Date: 13 November 2023
Our ref: Case: 14435
Your ref: TR030007

Immingham Eastern Ro-Ro Terminal

The following constitutes Natural England's formal statutory response for Examination Deadline 6.

IERRT Appendix 1: Comments on the HRA related to SPA / Ramsar birds (November 2023)

**Figure 9.9**

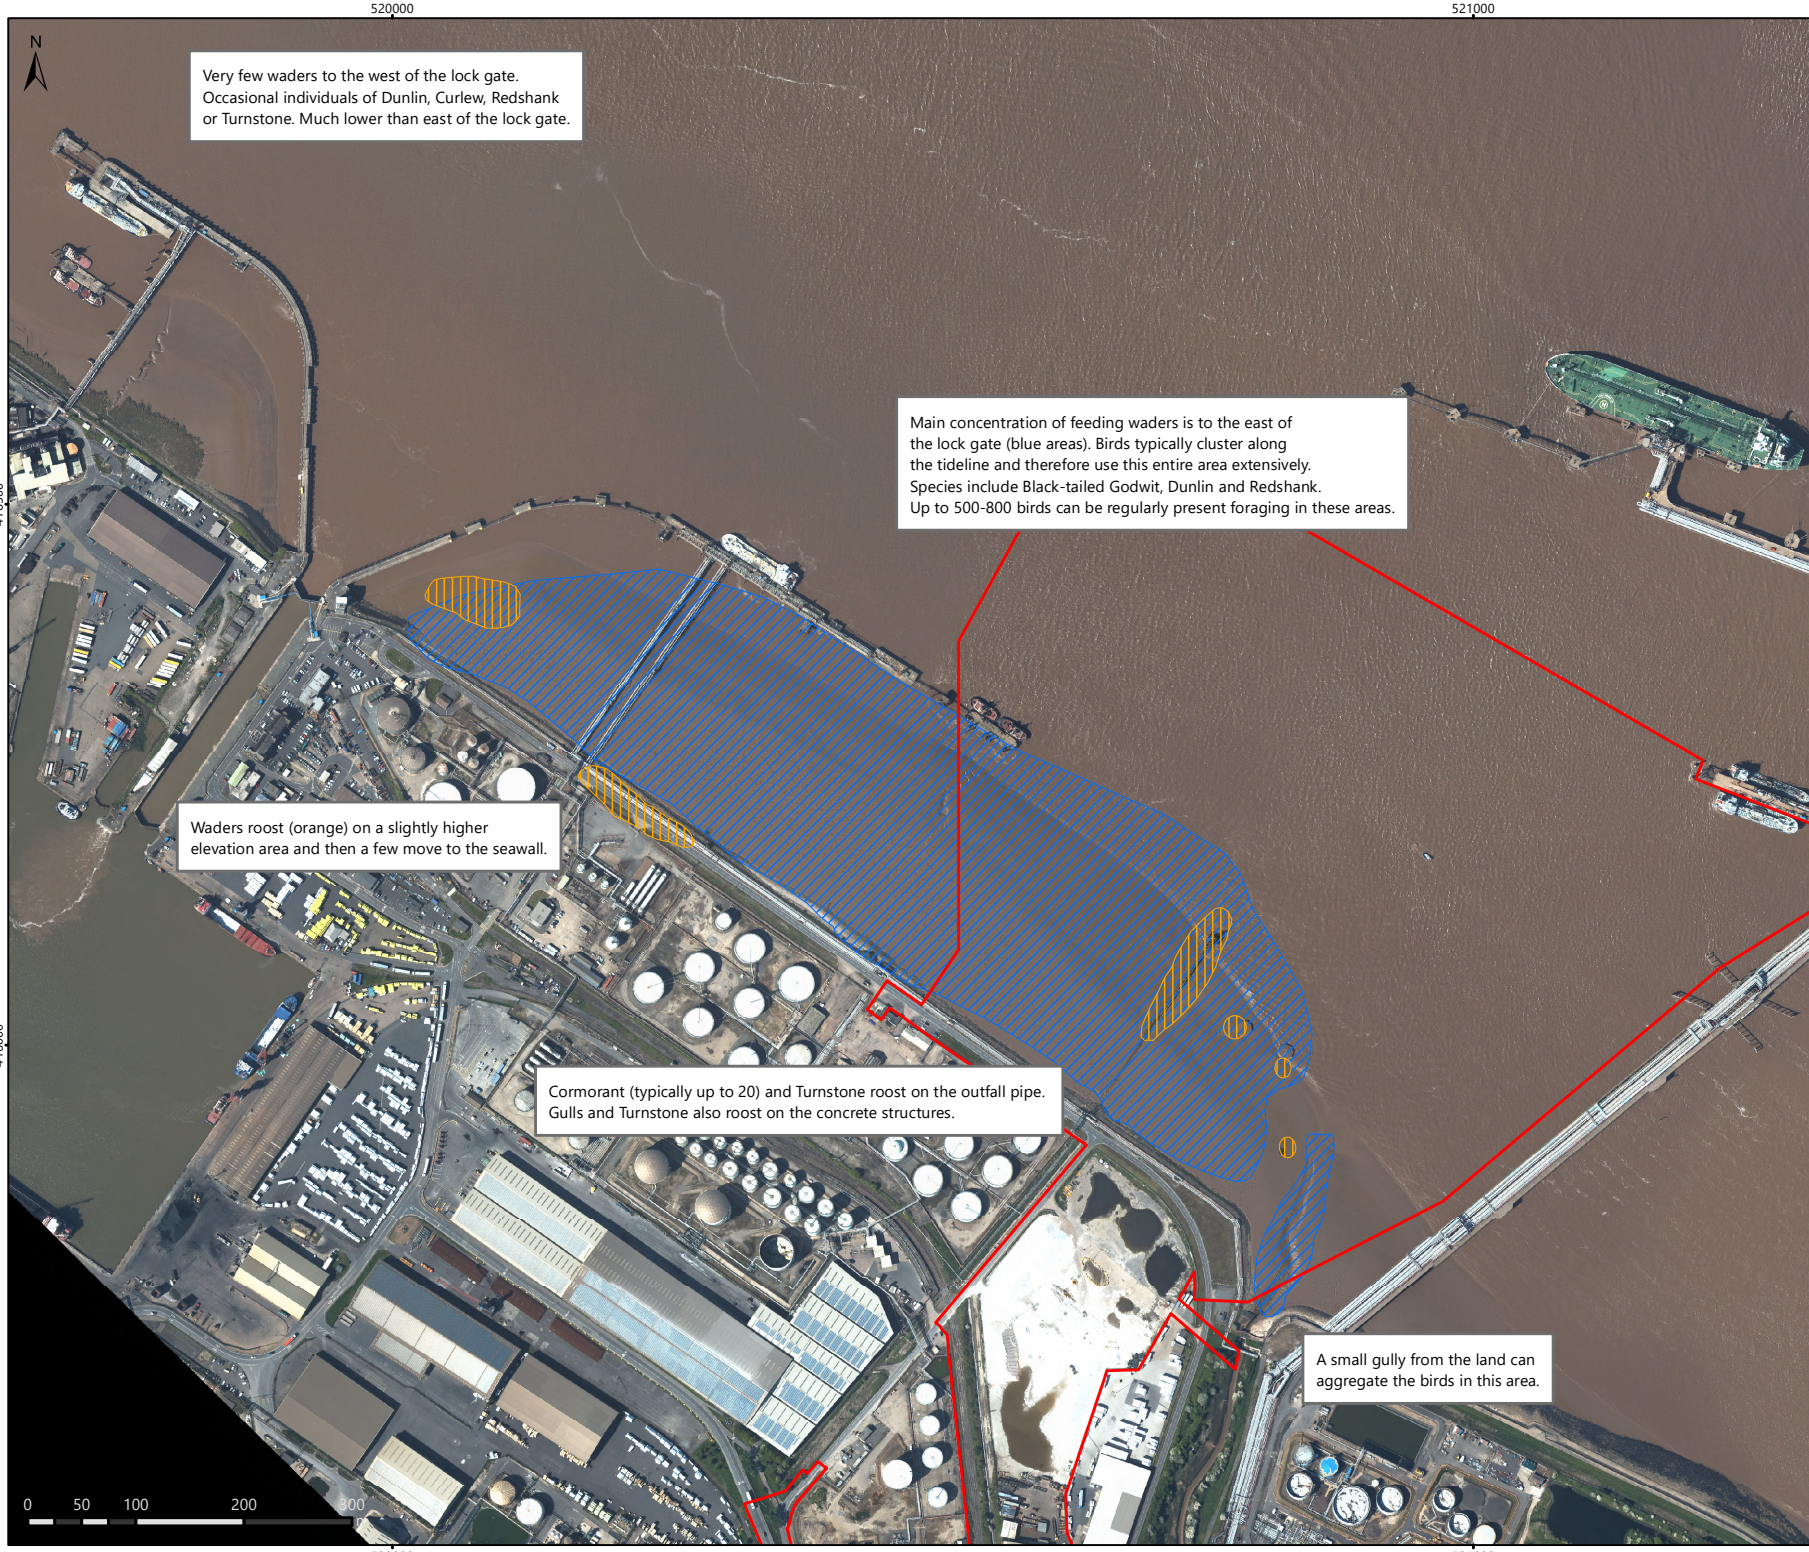
- 1) NE welcomes further information on this point including Figs 3 and 4 showing the numbers and locations of foraging and roosting birds in the existing enclosed spaces within sector B. This provides some reassurance that birds may well continue to use the area around the new jetty even though it will be more enclosed and potentially has greater disturbance from people than before construction. We recommend that post construction monitoring is conducted to identify whether similar numbers of birds continue to use sector B once the jetty is in place. This monitoring will provide evidence for future port projects.

**Figure 9.11**

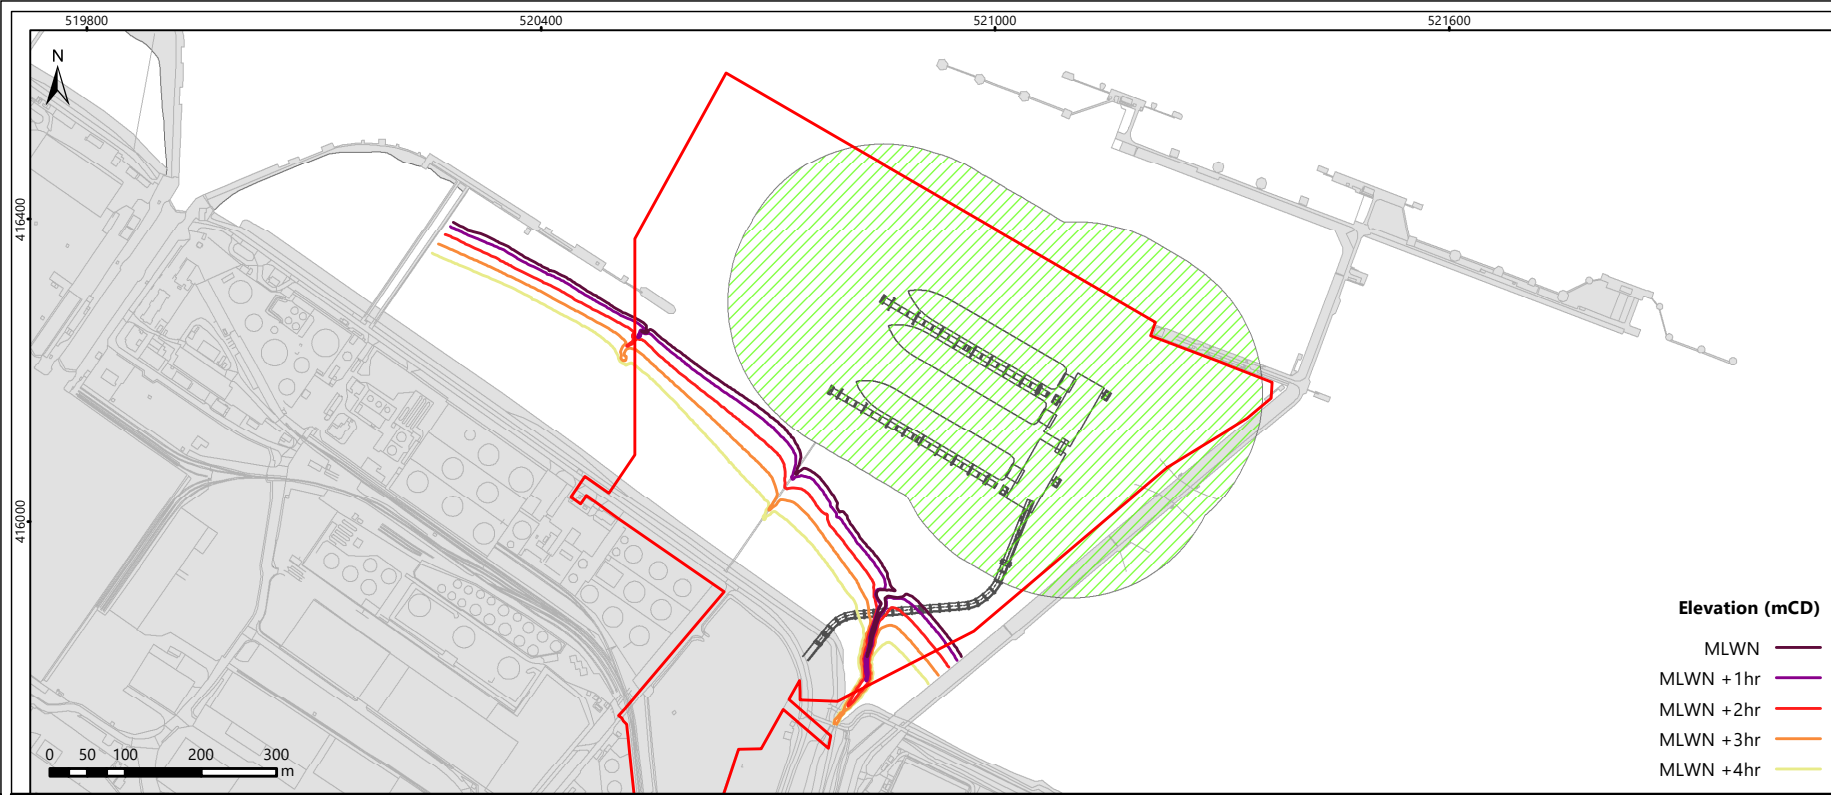
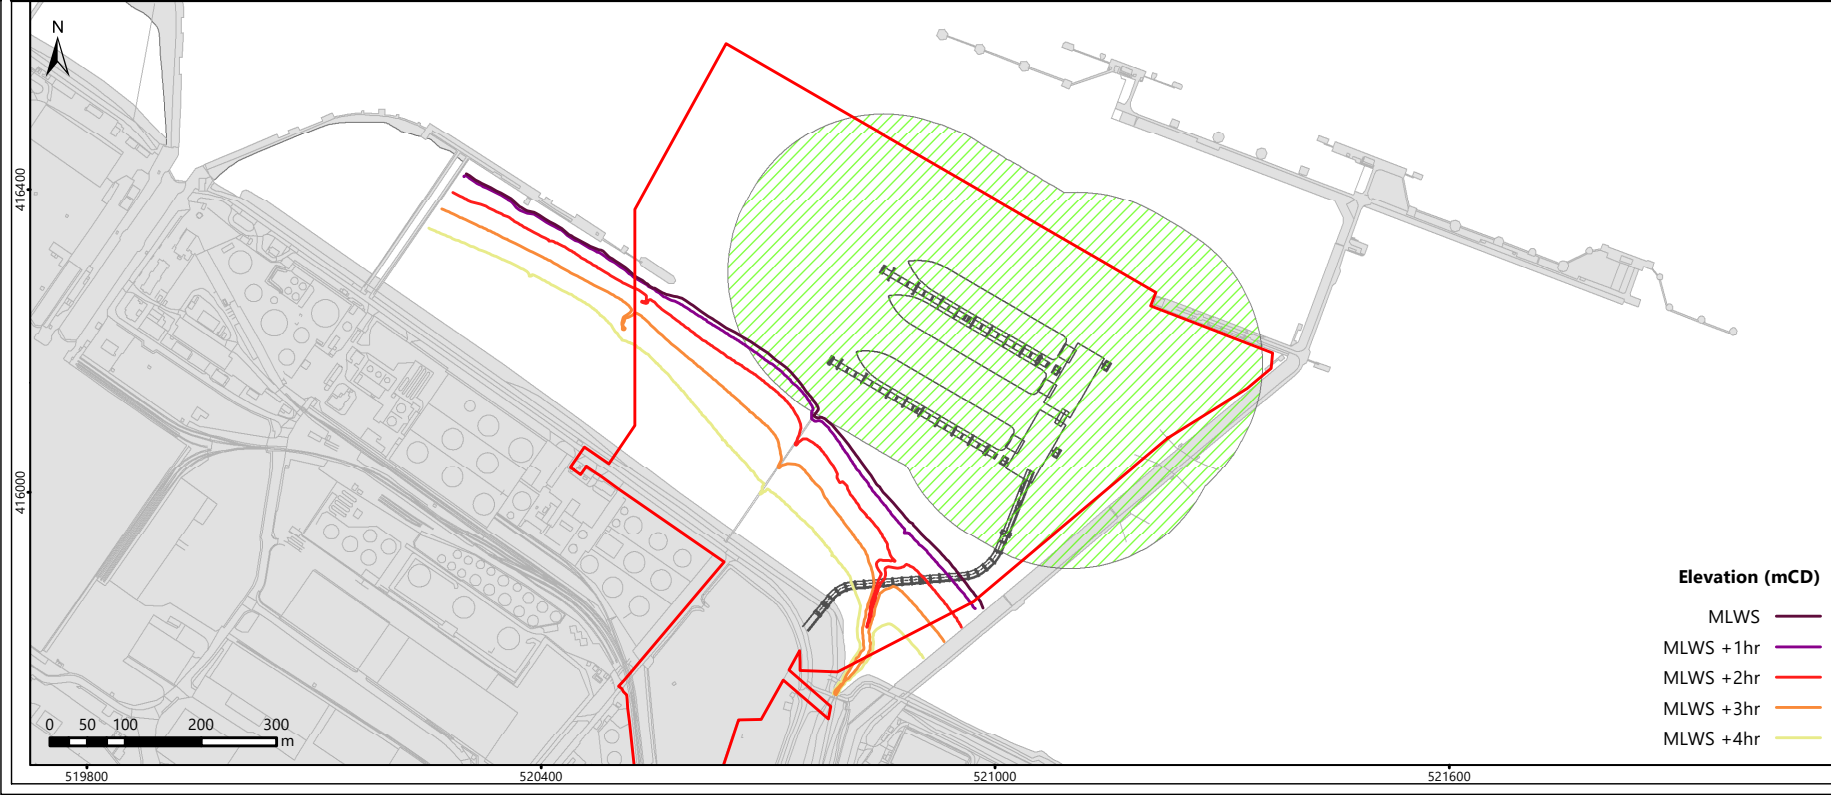
- 1) Appendix E includes Fig E.1 which shows noise modelling for piling on the outer pier, but does not include Fig 2 which shows noise modelling on the inner pier and approach jetty (this information is required for a thorough assessment). It is suggested that Fig 1 and Fig 2 of the predicted airborne noise (LAmax) during piling indicate that beyond 200m from the noise source noise levels will be below 70 dB and that this is considered to define the area that will result in the majority of bird disturbance. Natural England acknowledges that 200m is an acceptable disturbance distance for most construction activities within a port environment where birds will show some habituation to human activity. However, Natural England advise that a precautionary approach is taken to noise disturbance distances for piling. We recognise that birds are highly likely to be disturbed where noise levels exceed 70 dB LAmax. However there may also be effects on birds between 55 and 70 dB, whilst we recognise that this noise level impacts on a large area of mudflat, we consider that 200m does not represent a precautionary approach and advise that the noise disturbance zone should be larger, such as 300m from noise source.

- 3) **Mitigation:** No restrictions are being proposed for work on outer pier, but this would need to be reviewed should the disturbance distance be increased.
